Subject: Objection to the application Granting Development Consent for the Viking CCS Pipeline Project

To whom it may concern

TITLE THE IMMINGHAM FACILITY PLOT PLAN

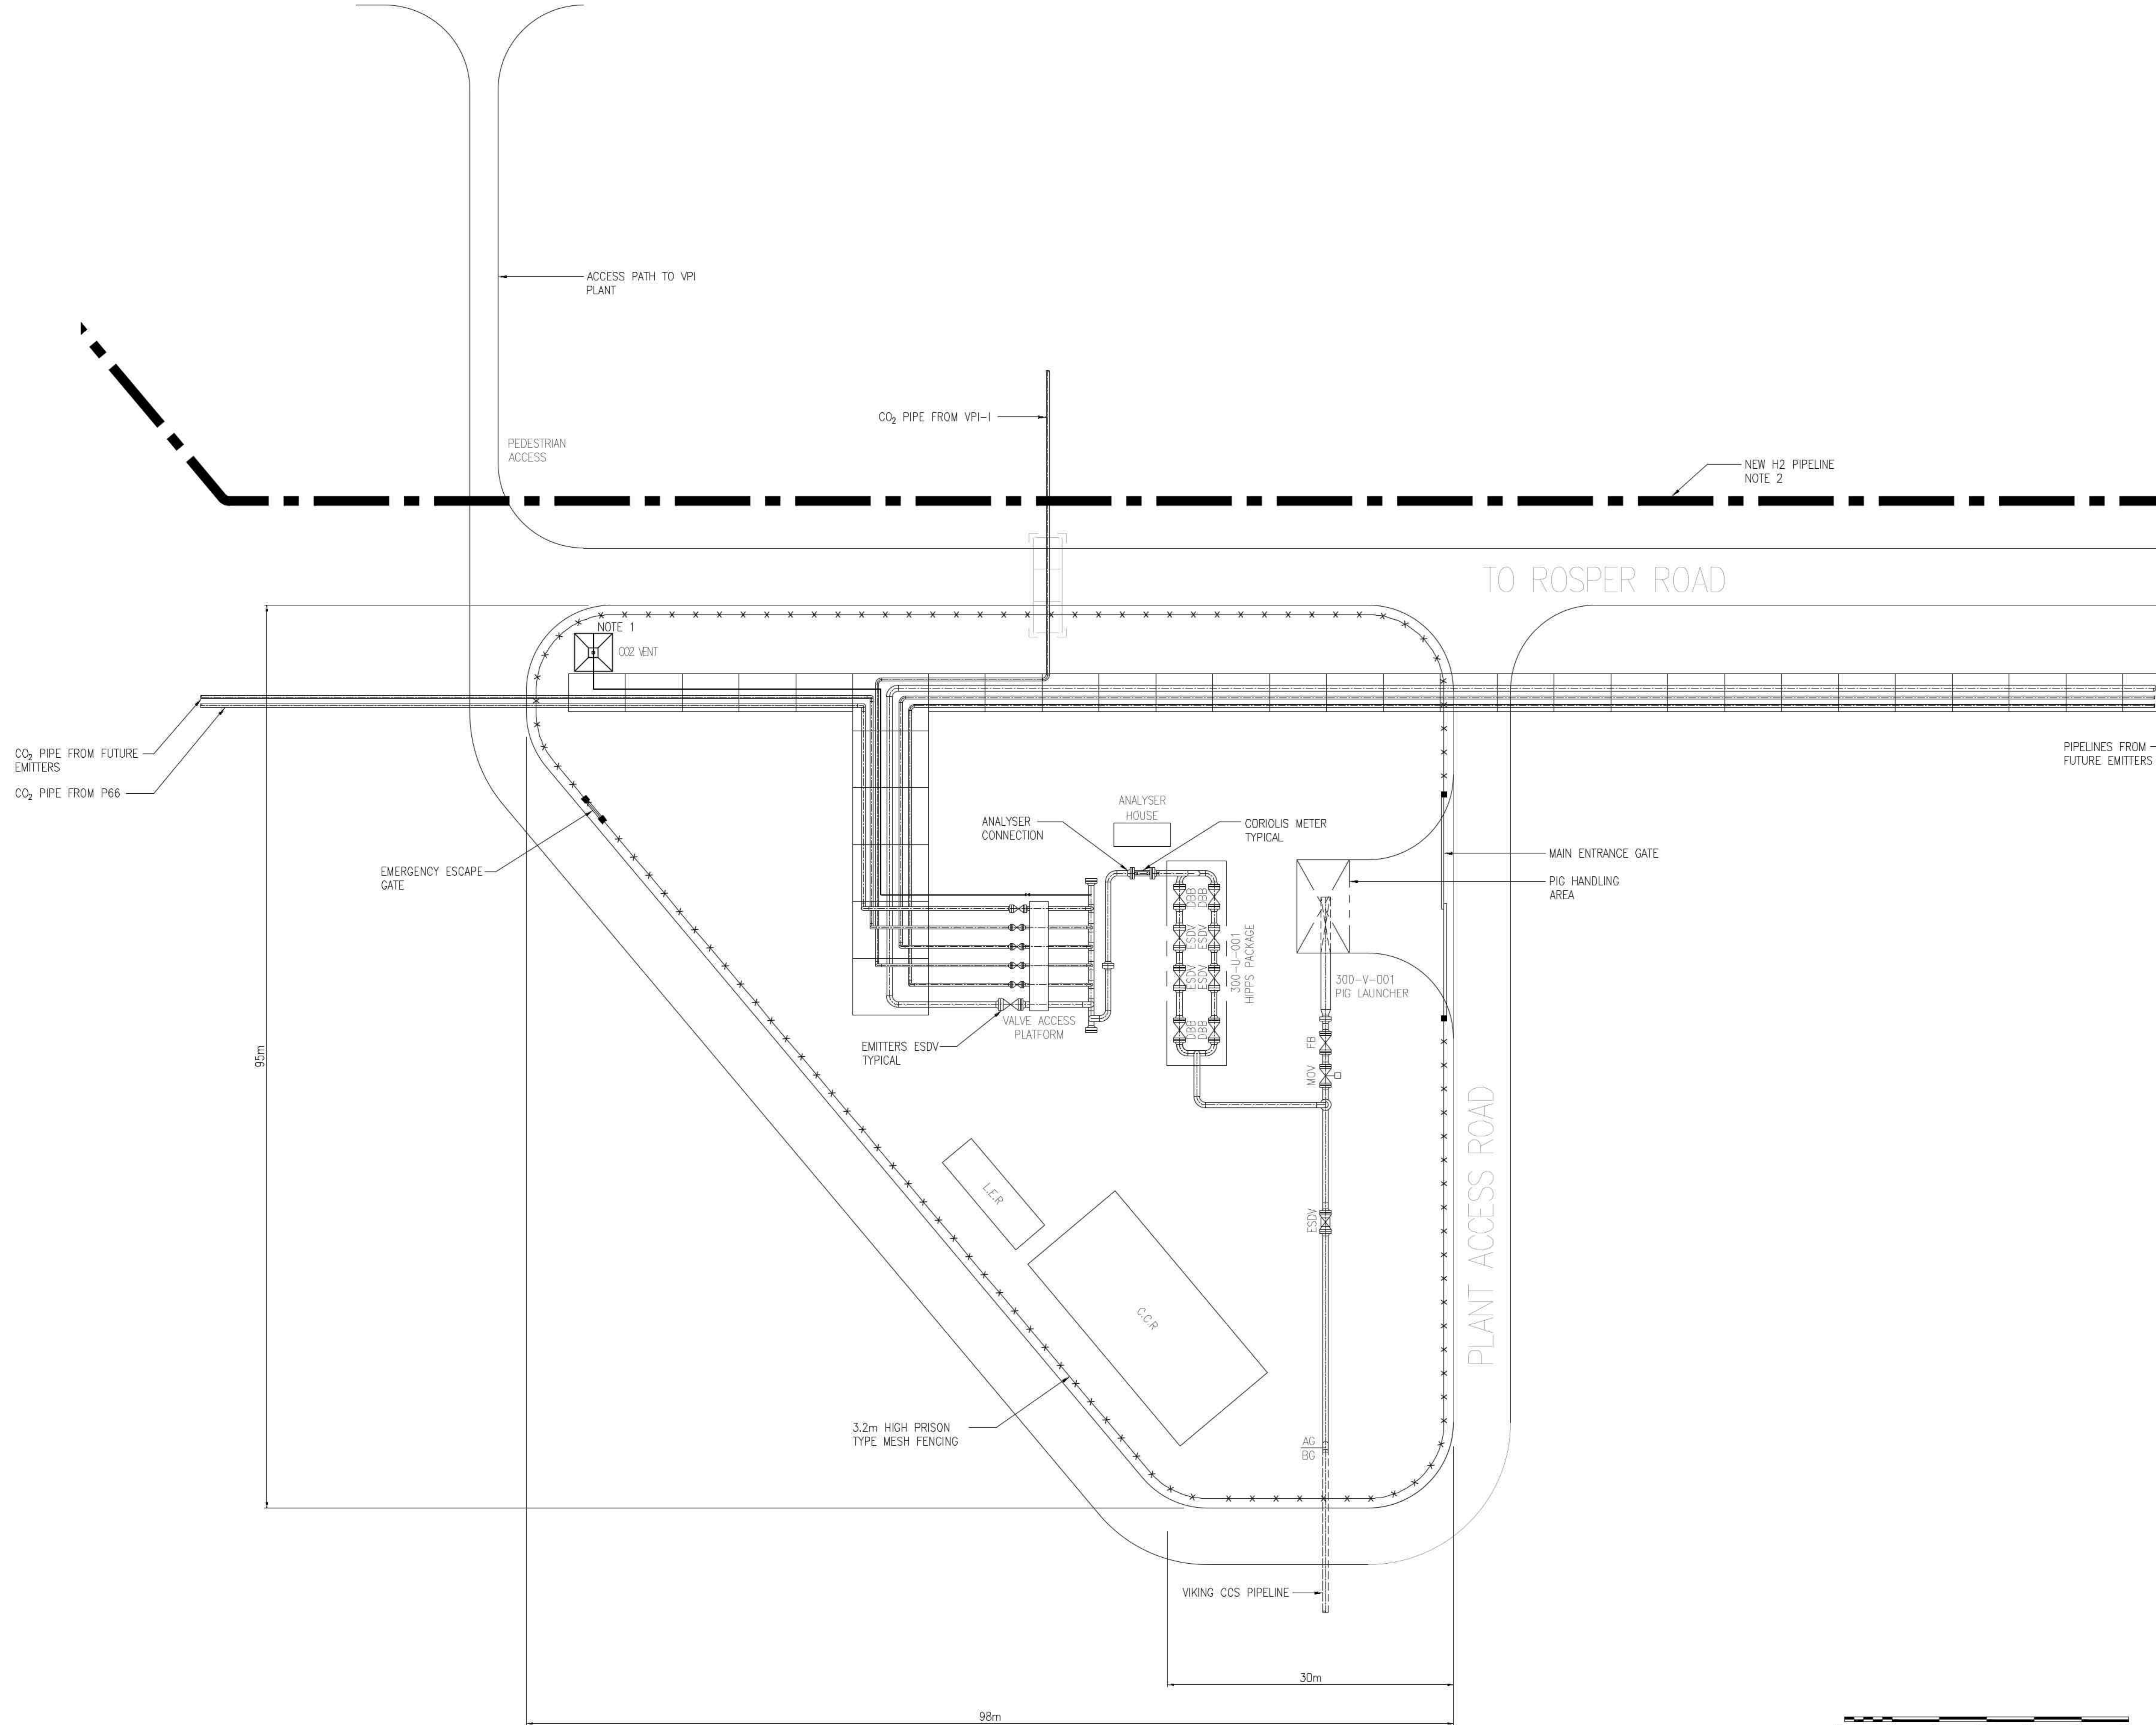
2) in the event an emergency depressurisation had to be conducted as per the above figures a significant volume of CO₂ would have to be vented. A 25m stack will route to CO₂ to an assumed "safe" height but you must agree is very much dependant upon metrological condition at the time of release i.e. if nil wind there will minimal to no dispersion and CO₂ will sink to the ground level very quickly - CO₂ when changing to gas phase cools to between -54 Celsius and -78 celsius - this will be significantly colder than the ambient temperature even on the coldest of winter days and is extremely likely to result in the formation of micro weather system at the vent/breach site whereby a convective downdraft will be formed and fed by the continued release /venting of CO₂. As long as the downdraft air is denser (colder) than the environmental air at the same level, it will continue to
